Application for DCO by FOSSE GREEN
Representation by Interested Party reference [REDACTED]
Deadline 5A

Section B Comments on REP5-025 Applicant's response to Deadline 4 Submissions

Noise Contours - Operational Phase
Distributed BESS

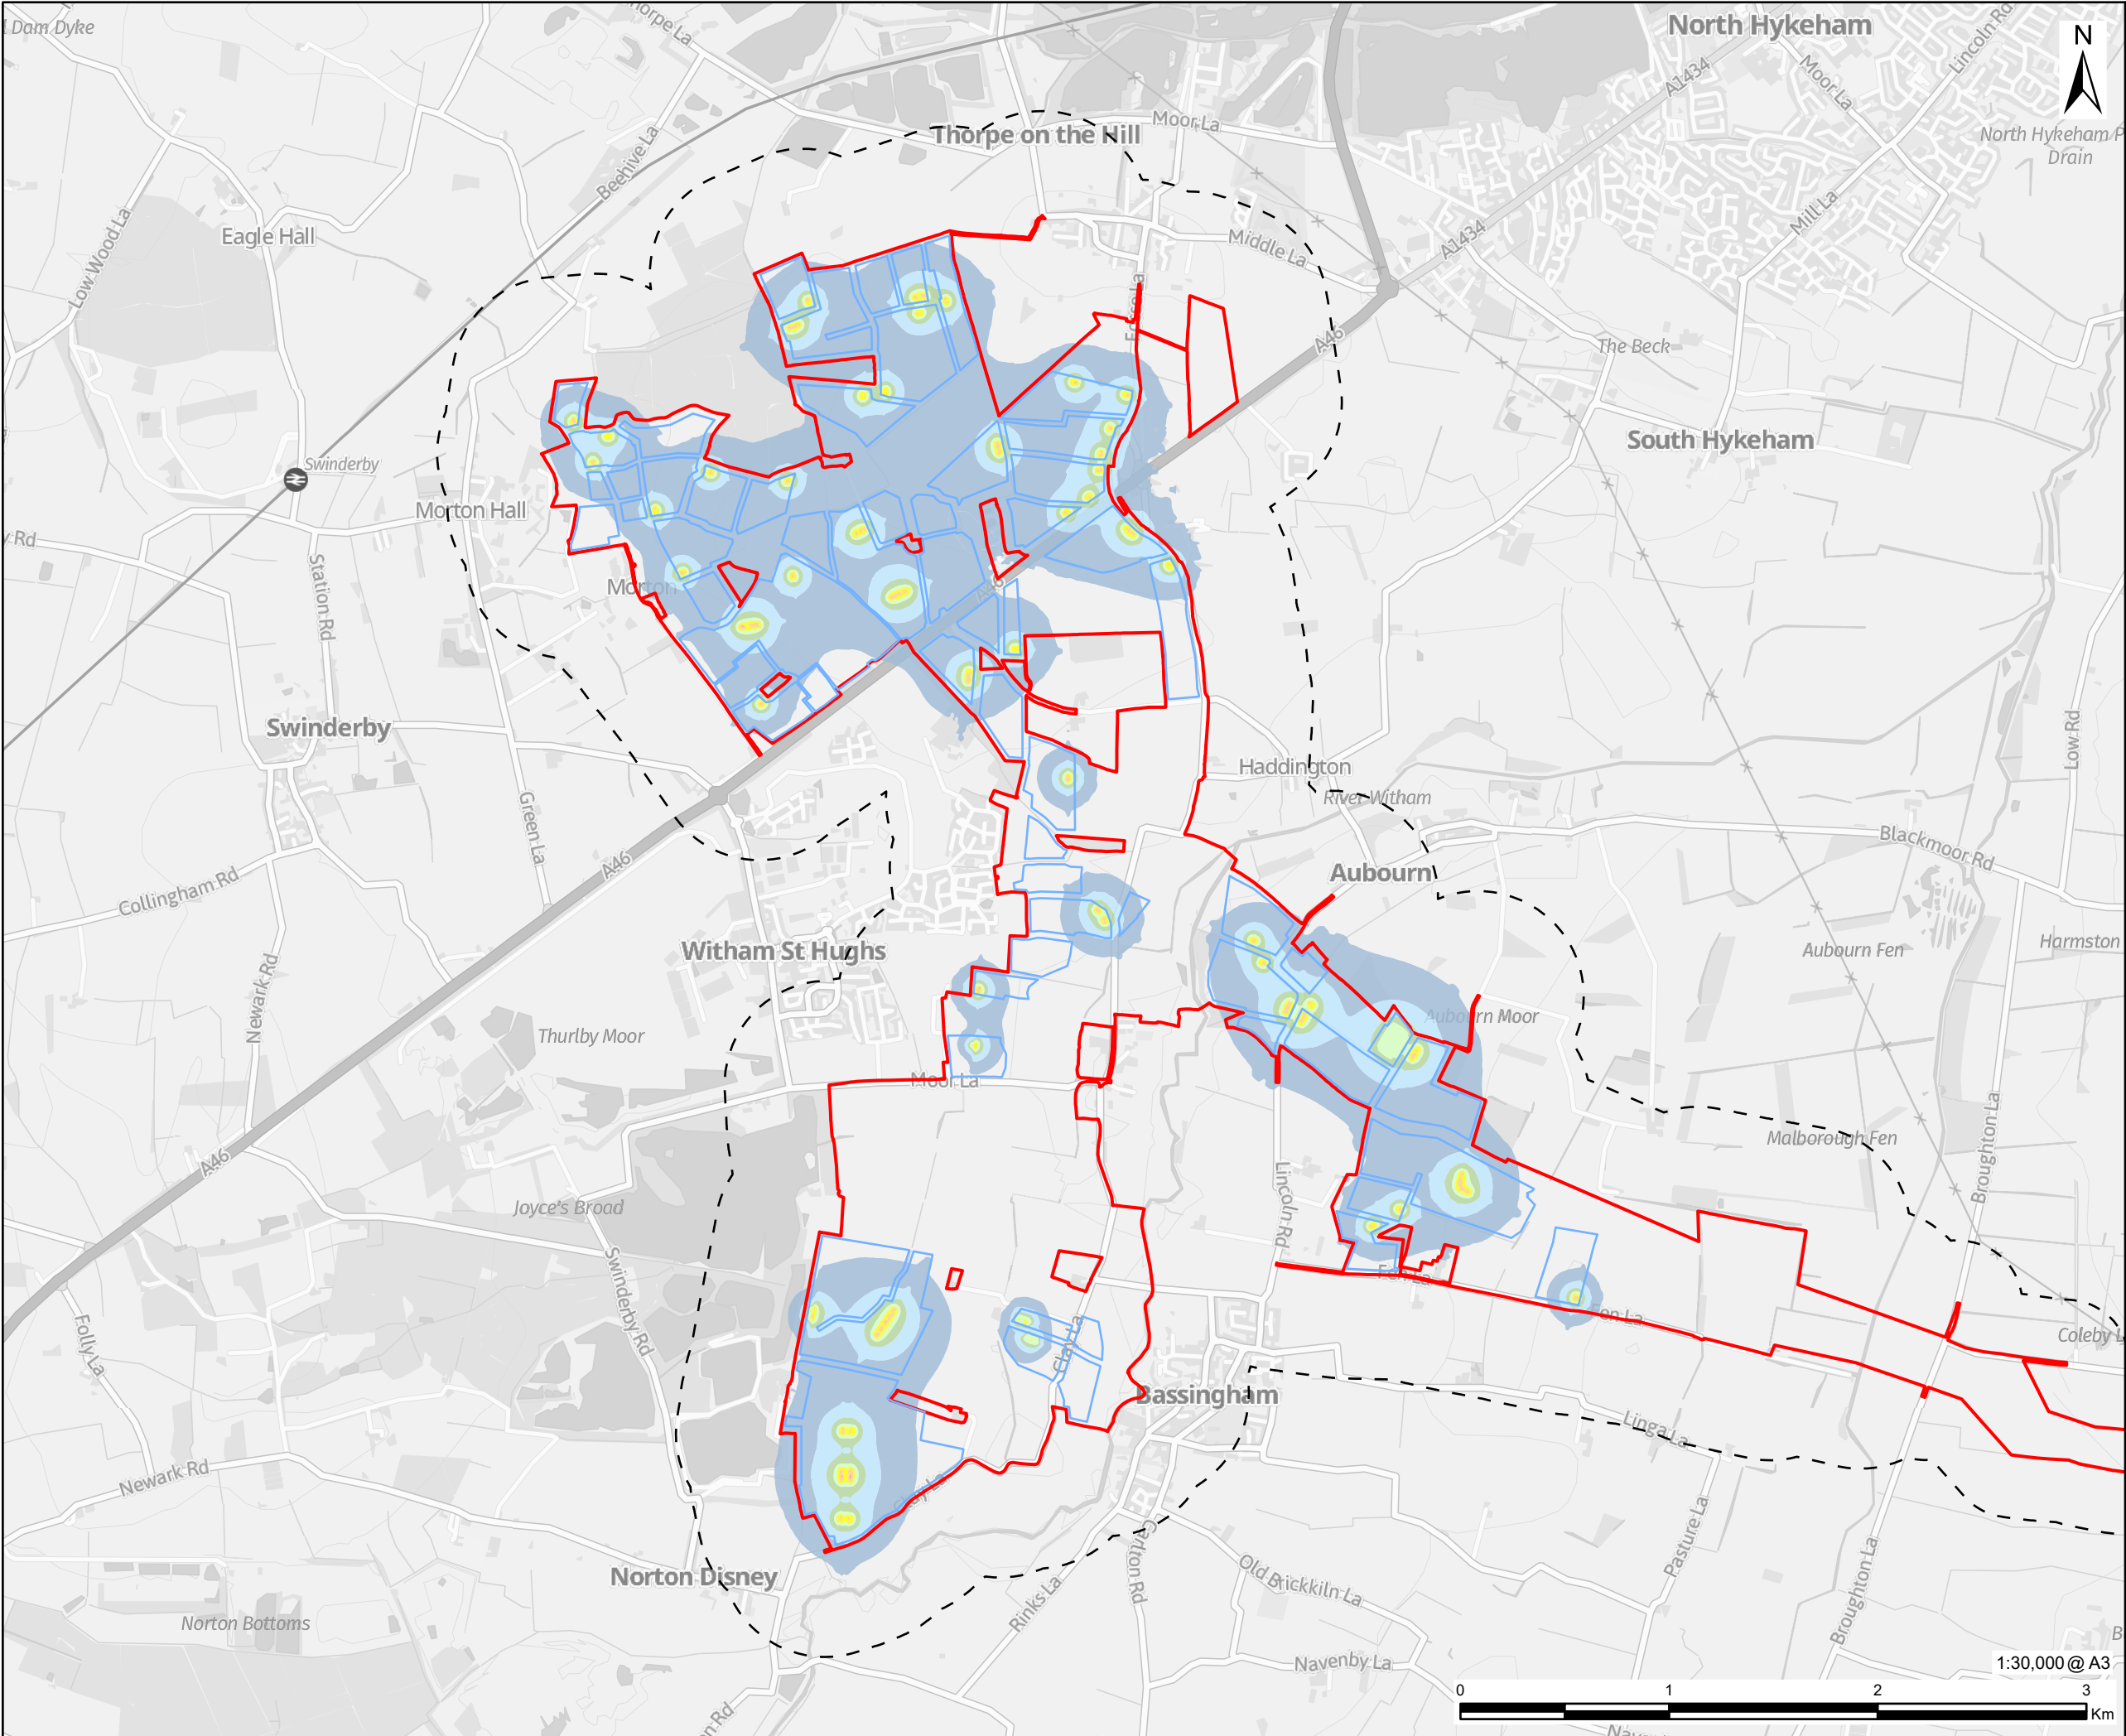
5.1.7 The Applicant states that operational noise has been assessed and predicted to remain below relevant thresholds at public rights of way. It is not clear whether the Applicant is also asserting that operational noise is “below relevant thresholds” along the new proposed permissive paths. I have made submissions about the operational noise along the existing PRow in REP1-106 (paragraph 5.1), REP2-061 (paragraph 7) and REP5-045 (paragraph 3). In summary, my contention is that as the Applicant has not taken sound levels along the existing PRow, it is not able to assert that the operational noise along those routes will be “akin” to or “in line with” the existing noise levels. It can be seen from the noise contour

plans (AS-063) that the operational noise along the majority of the proposed new permissive paths around Thorpe on the Hill for the distributed BESS option will be between 35 and 55dB. The route of the new permissive paths around TOTH will be alongside the A46 and Fosse Road where traffic noise will predominate.
